**Drax Bio-Energy and Carbon Capture Storage  
Deadline 5**

**Comments on the Applicant's updated draft Development Consent Order (Rev 6 – document reference REP4-019 and REP4-022)**

**Comments on any other responses received by Deadline 4**

**1. Applicant's Summary of Oral Case at Issue Specific Hearing 3 (ISH3) - Rev 1 (document reference REP4-026) – in relation to Noise and Vibration**

Plate 1.21 - LT4 Night-time Histogram

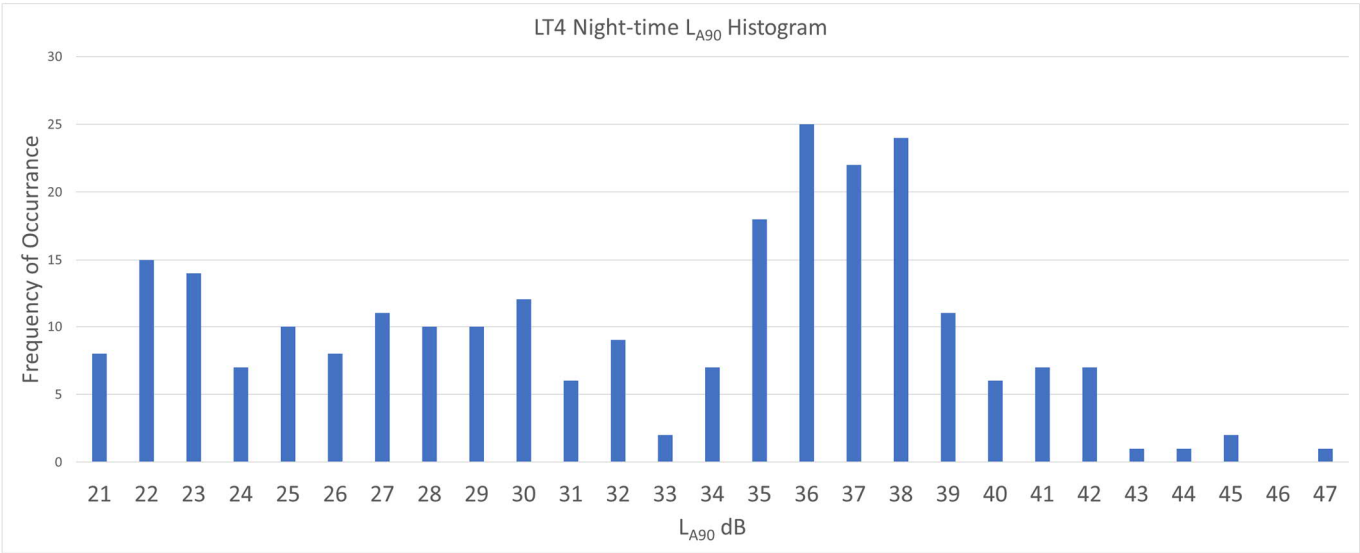
- There are some elements to the assessment methodology that favour the context case and worthy of emphasis:
  - Background noise levels at R6 and R14 are likely to be higher than those selected for the assessment. This is a consequence of the adopted assessment methodology which differs to that suggested within the standard and provides a much more conservative conclusion (Appendix 7.4 Baseline Noise Statistical Analysis – Plate 1.21: LT4 Night-time Histogram vs. BS4142:2014+A1:2019 Section 8 [Figure 4]).

The aforementioned depicts a deflated background noise level against an inflated rating level, thus potential for exaggerating the actual noise impacts.

As such, it is necessary to balance the onerous design implications of revisiting the indicative layout with the adverse night-time noise impacts at receptors R6 and R14, in the context of what is a conservative assessment of existing background noise levels and a worst-case scenario with all plant operating 100% of the time.
